CM 16/20/PL and CM/64/19/PL Langford, Horsemere Green Lane, Clymping

ADC Report and recommendations undated

Plot 8 deliberate misrepresentation by applicant MJH Homes to ADC

Drawing Title:
HOUSE TYPE-F1
FLOOR PLANS

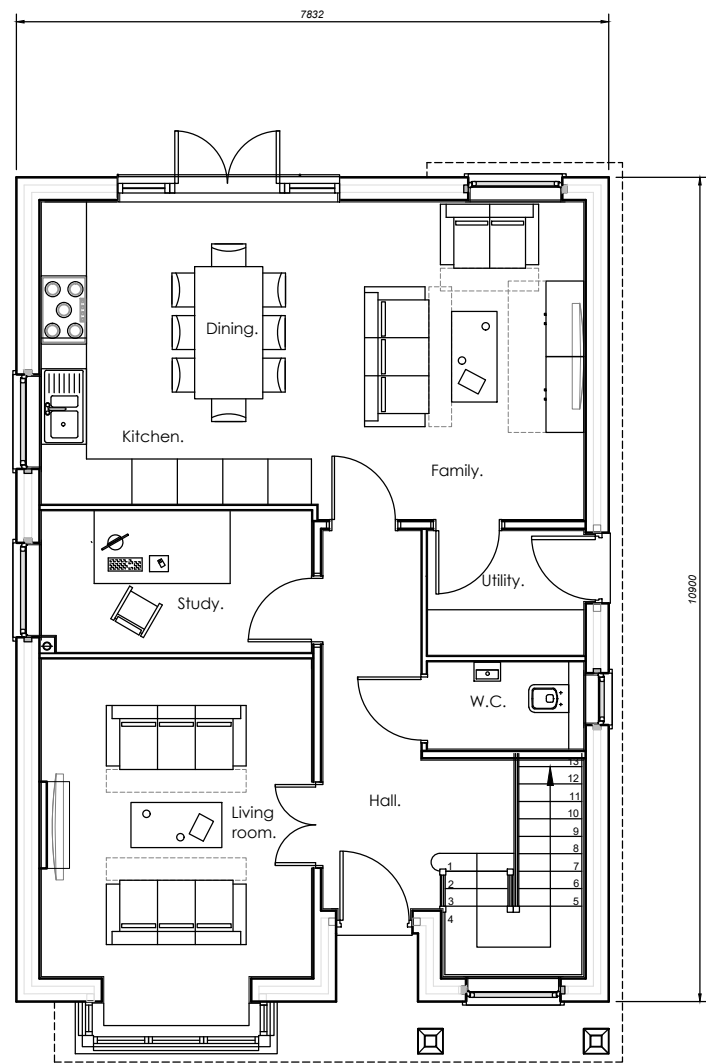
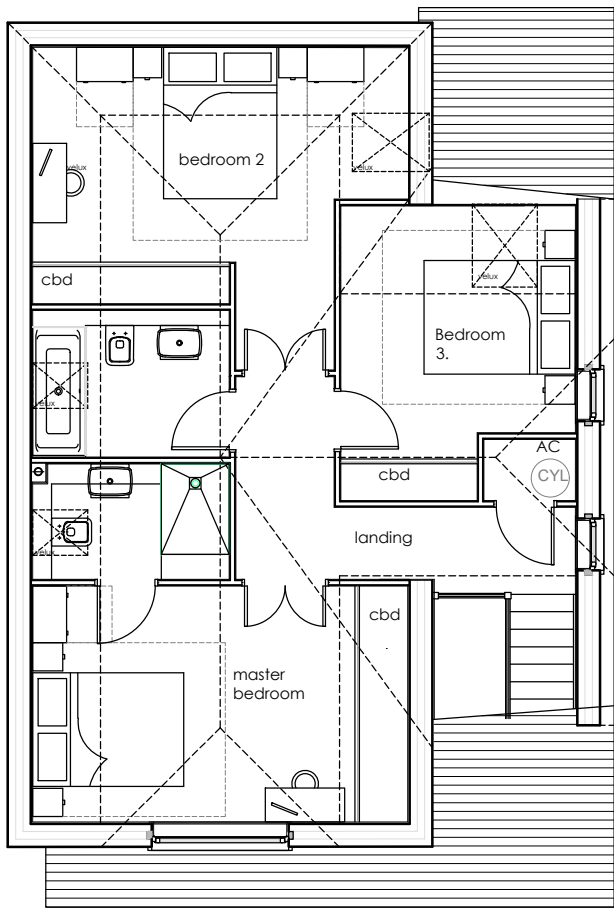
3. The value of my property has been very badly affected.
4. PLOT 8 runs the length of my boundary. An application for a 4-bed house type E was submitted and declined. House type F described as a 3-bed BUNGALOW but which in fact was a HOUSE with 2 bedrooms and 2 bathrooms on the first floor, and one bedroom on ground floor was submitted.

6. A proposal now for an even larger house, in every sense, F1.
7. Whereas before my outlook was that of natural woodland, the applicant proposes impose that I should have a view of this high expanse of brick wall and roof tiles.

9. Windows on the first floor which open out directly onto by back garden and can see directly in my bedroom windows, back windows generally and the whole of my back garden is completely unacceptable and a total invasion of privacy

13. If the applicant was to reduce the roof height to single storey, ie, that of a bungalow, as proposed, and lower the ground level, this would fall in line with their proposal of '2 x 3-bed bungalows' made to Arun District Council.

Project:
LANGFORD
HORSEMERE GREEN LANE
CLIMPING
Drawing Title:
HOUSE TYPE-F1
ELEVATIONS

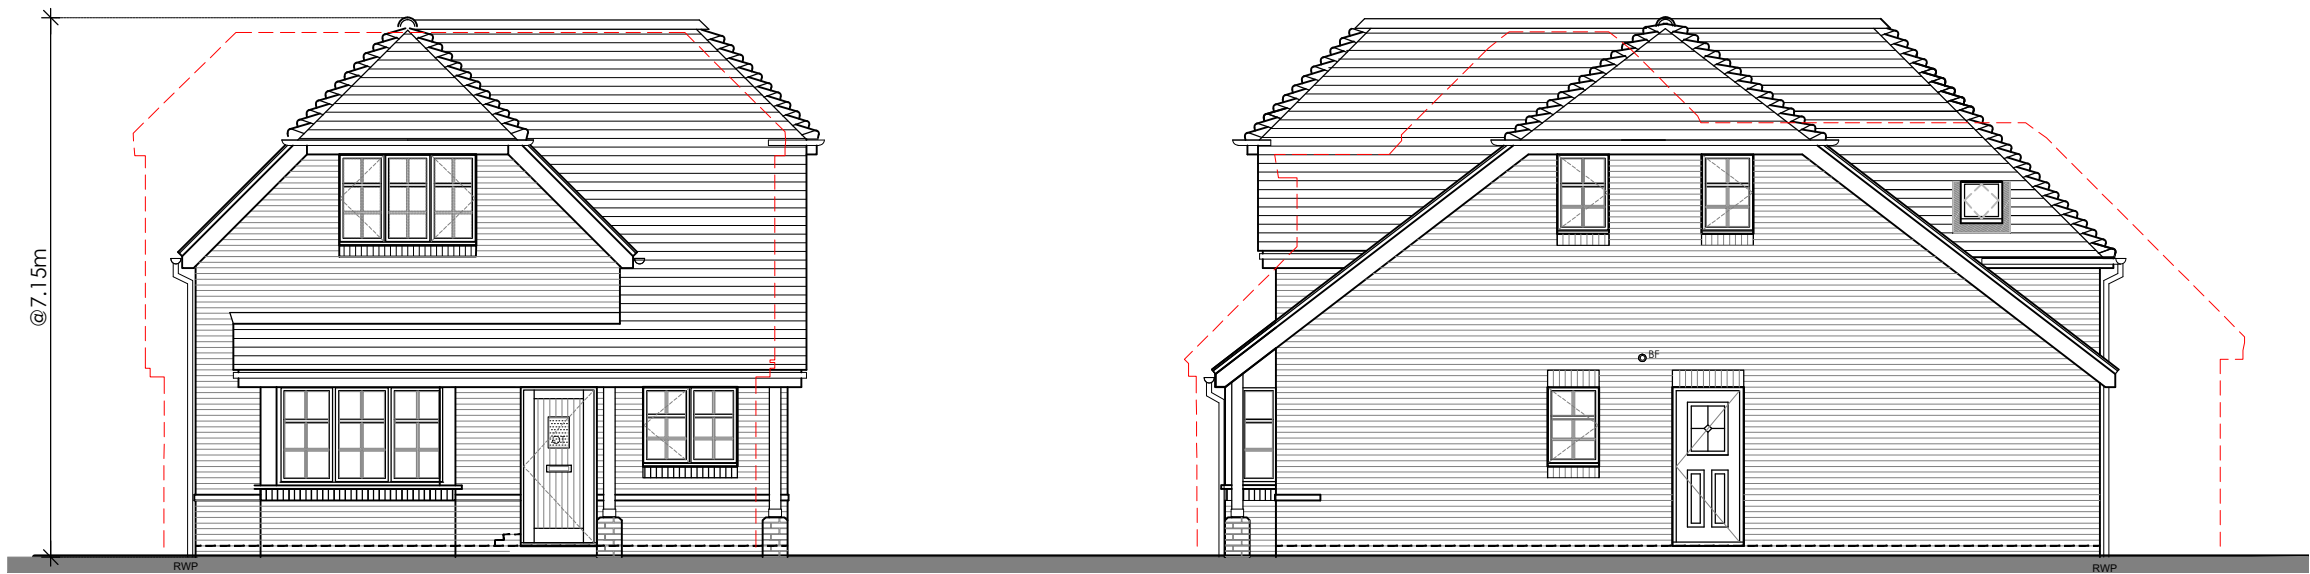
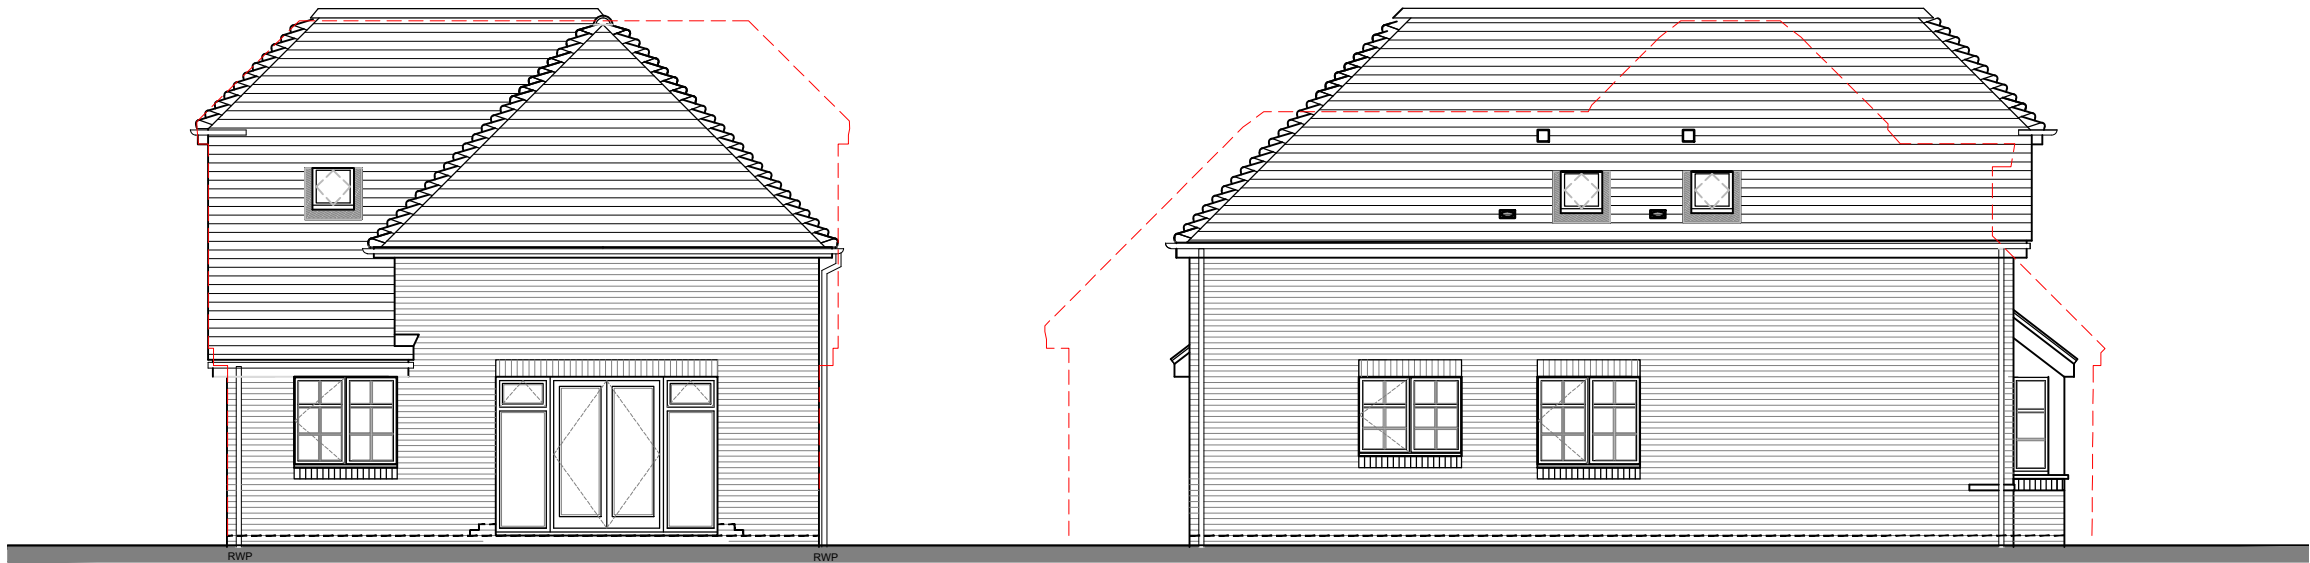
8. The whole length of the proposed house runs the whole length of my boundary, with permanent structure within feet of my fence/ property. This is very intrusive, and the high roof line will obliterate light for the majority of the day, completely unacceptable. I speak on behalf of myself and my affected neighbours.
